Application for a non-material amendment following a grant of planning permission.

Demolition of existing buildings and erection of 30 residential dwellings (Use Class C3) comprising 24x flats and 6x houses together with associated access, landscaping and surfacing works
At:
Queensmead House, Queensmead Road, Loudwater, Buckinghamshire

Due to Covid the availability and manufacturing times for the originally approved window frames are unrealistic to be able to complete the project on time, thus delaying much needed affordable housing.
The proposed amended window frames look very similar and colour is identical.

client	<b>MEARS</b> MEARS NEW HOMES 26 - 28 HYDE WAY, WELWYN GARDEN CITY, HERTFORDSHIRE AL7 3UL.
site	<b>QUEENSMEAD HOUSE, HIGH WYCOMBE.</b>
drawing title	<b>APARTMENT BLOCK ELEVATIONS SHEET 2</b>
drawn	DR
date	01.08.19
scale	1:50 @A0
drawing number	2700040 - A - APT - 501
revision	C6

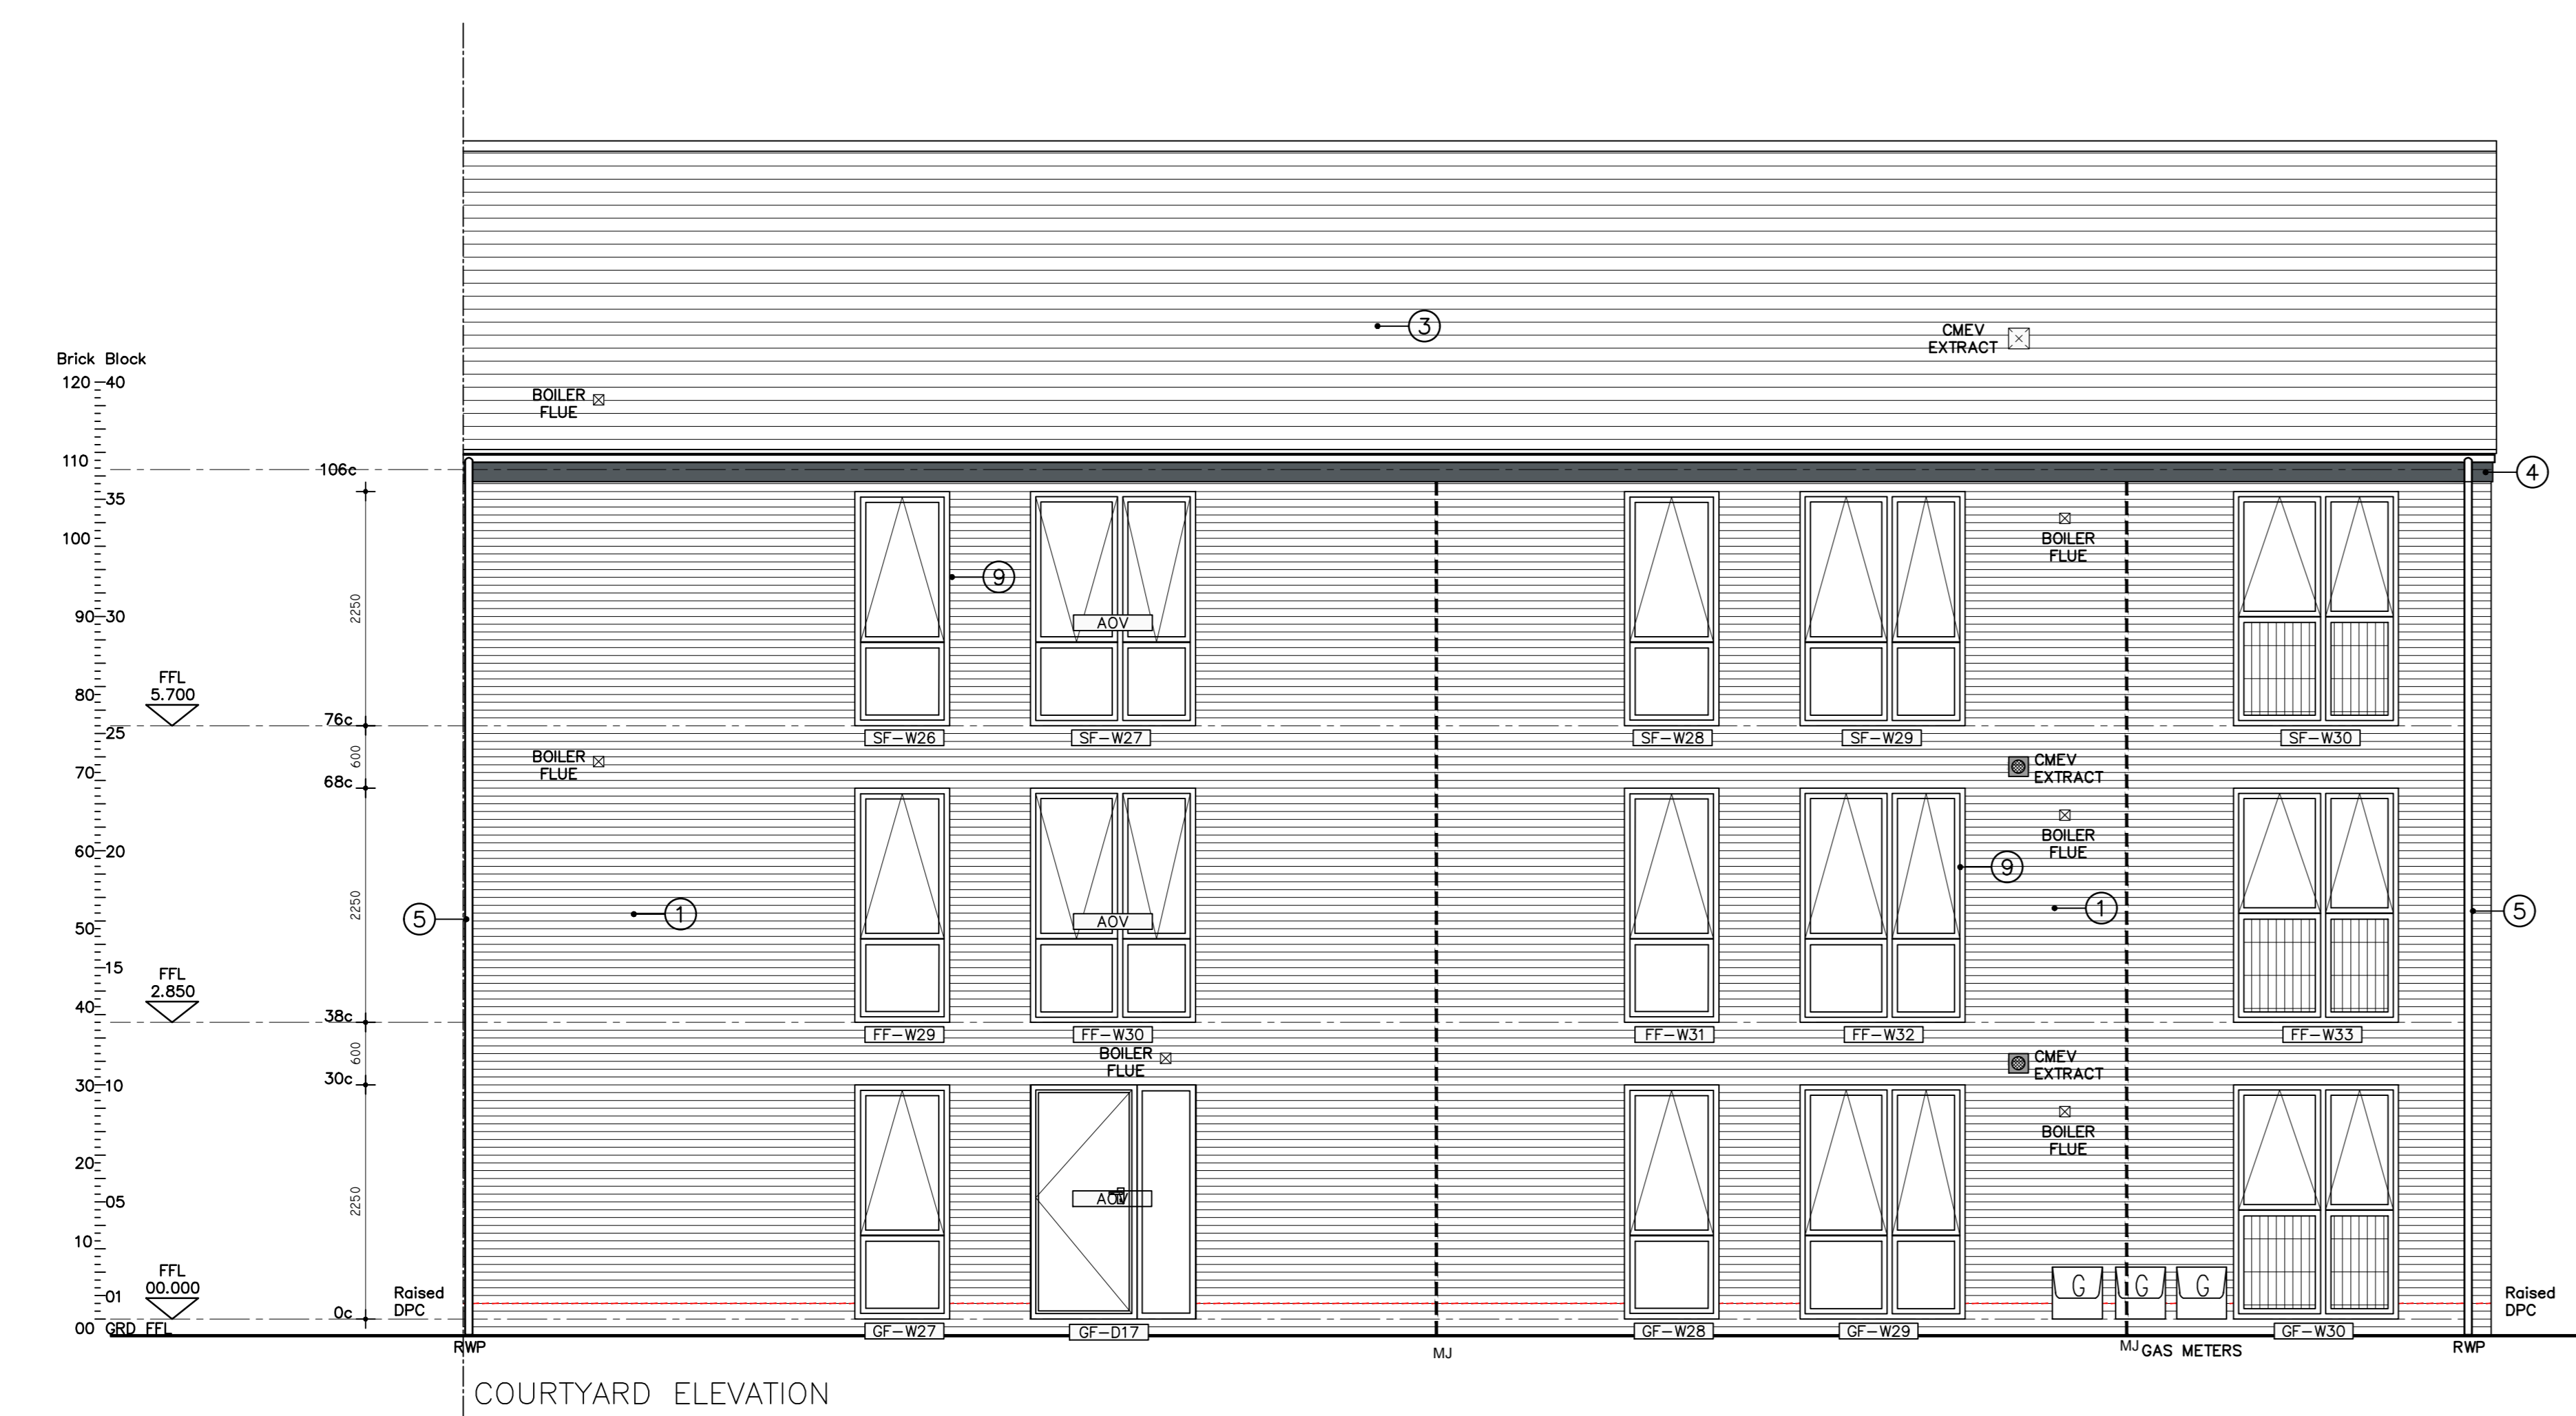
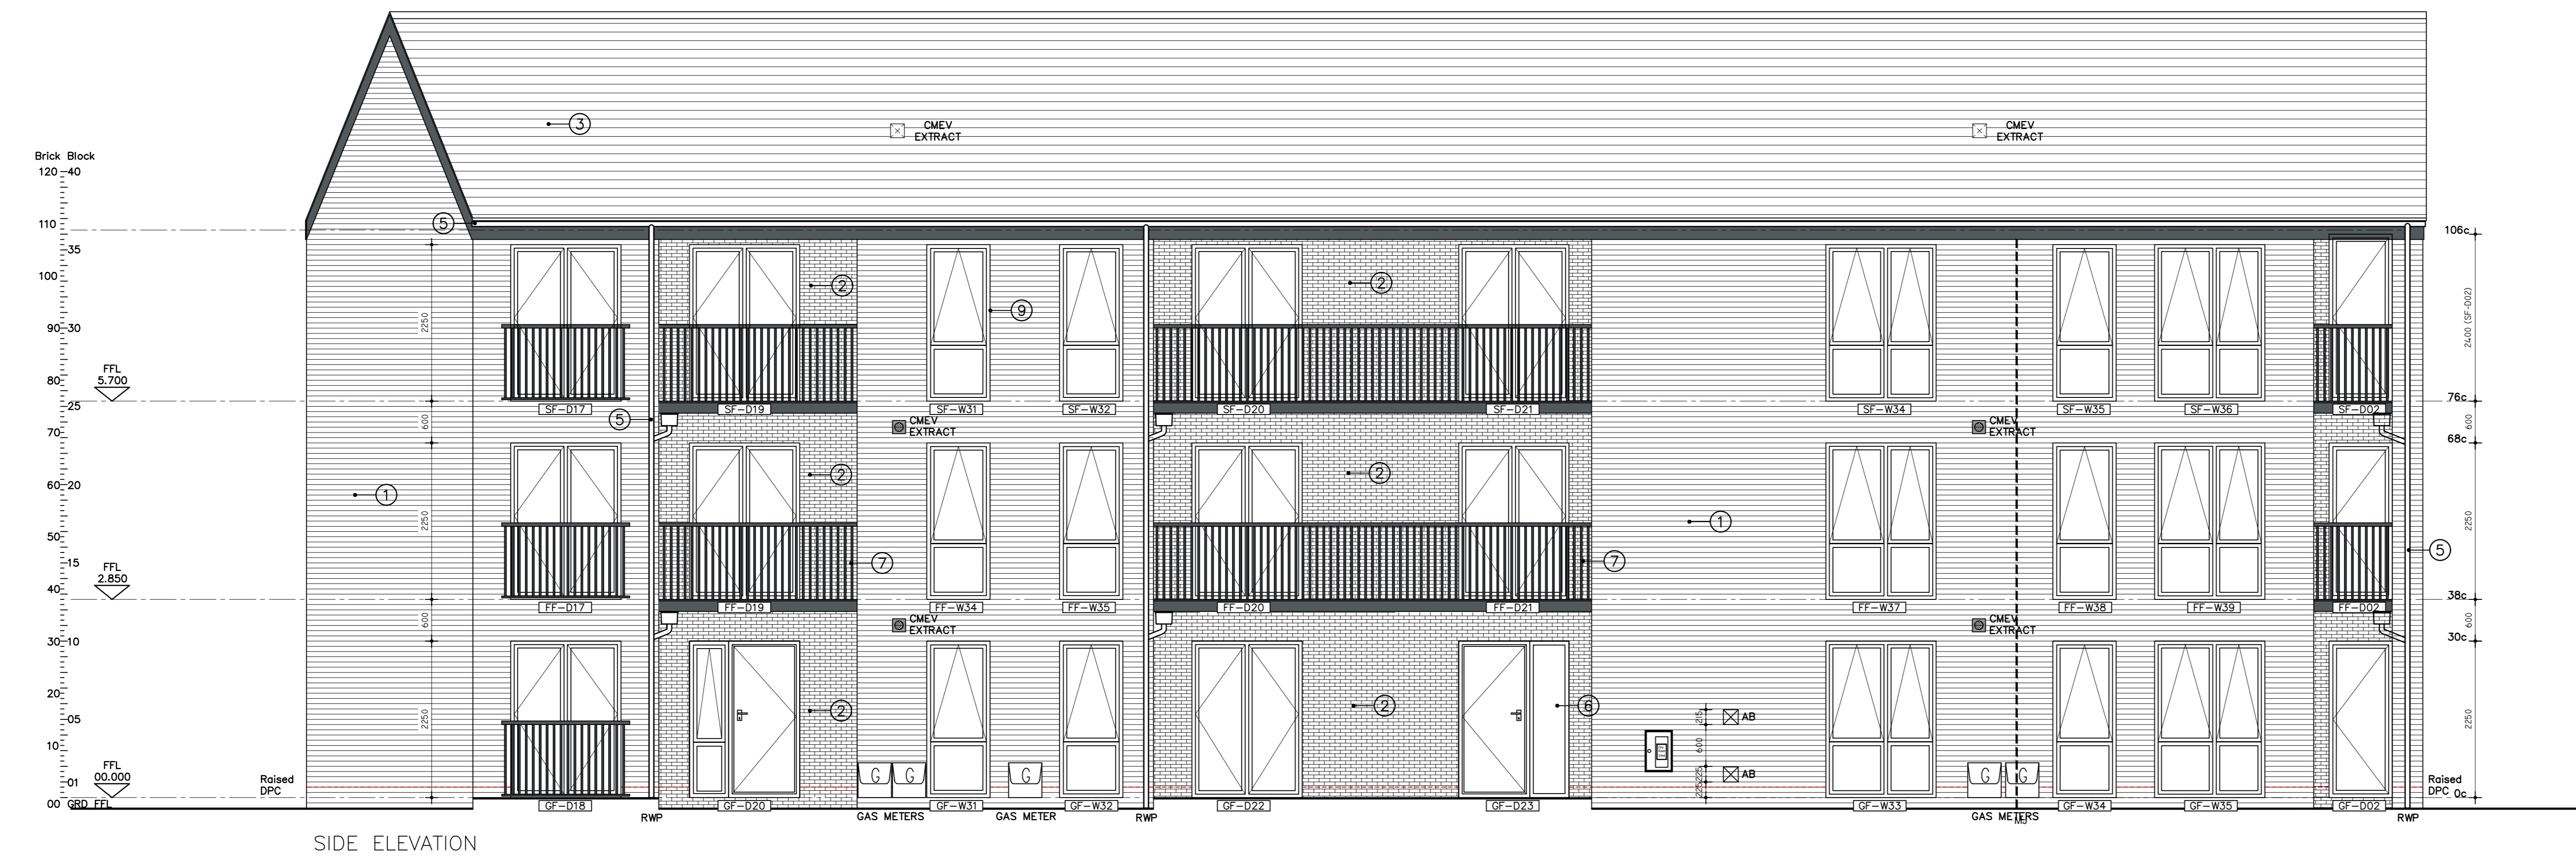
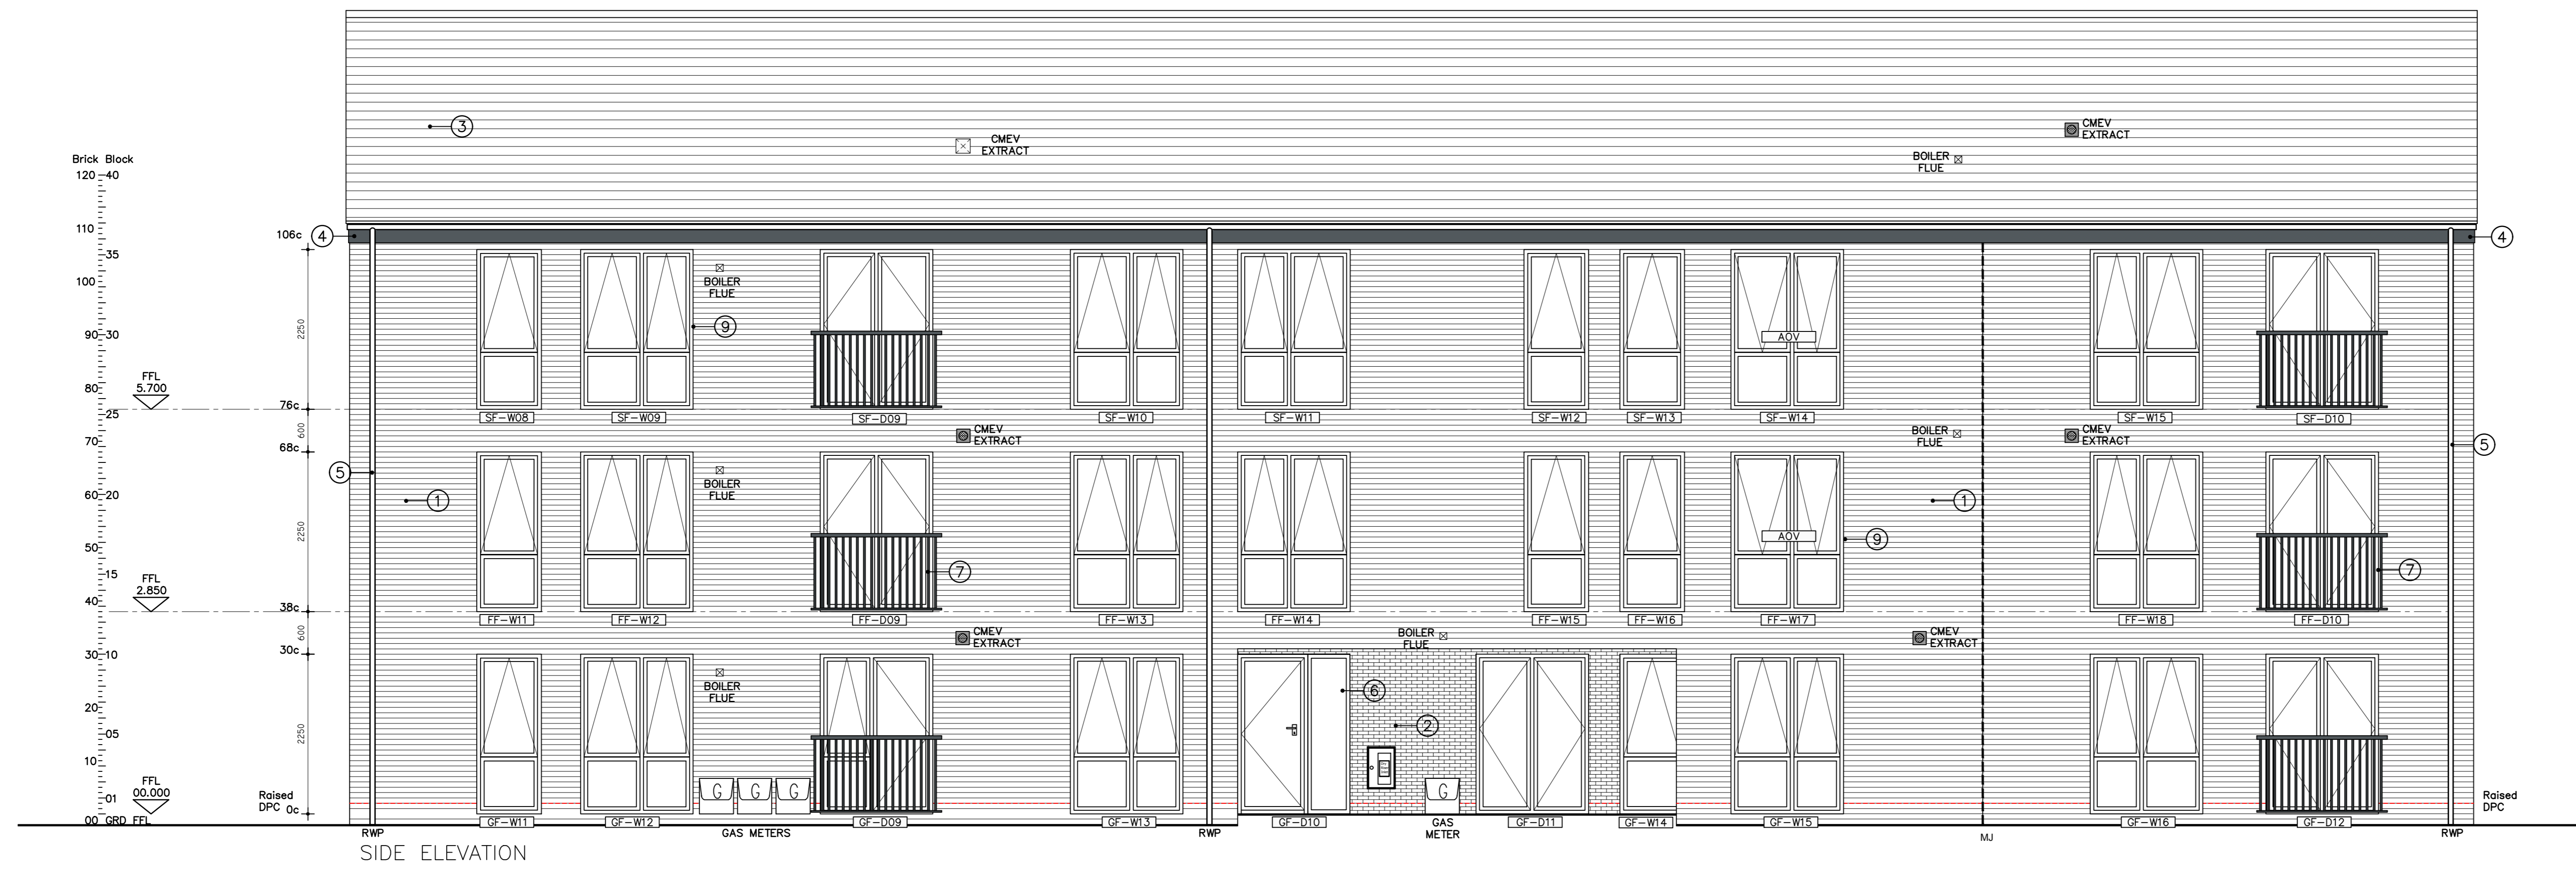
2700040-A-APT-501 rev C5
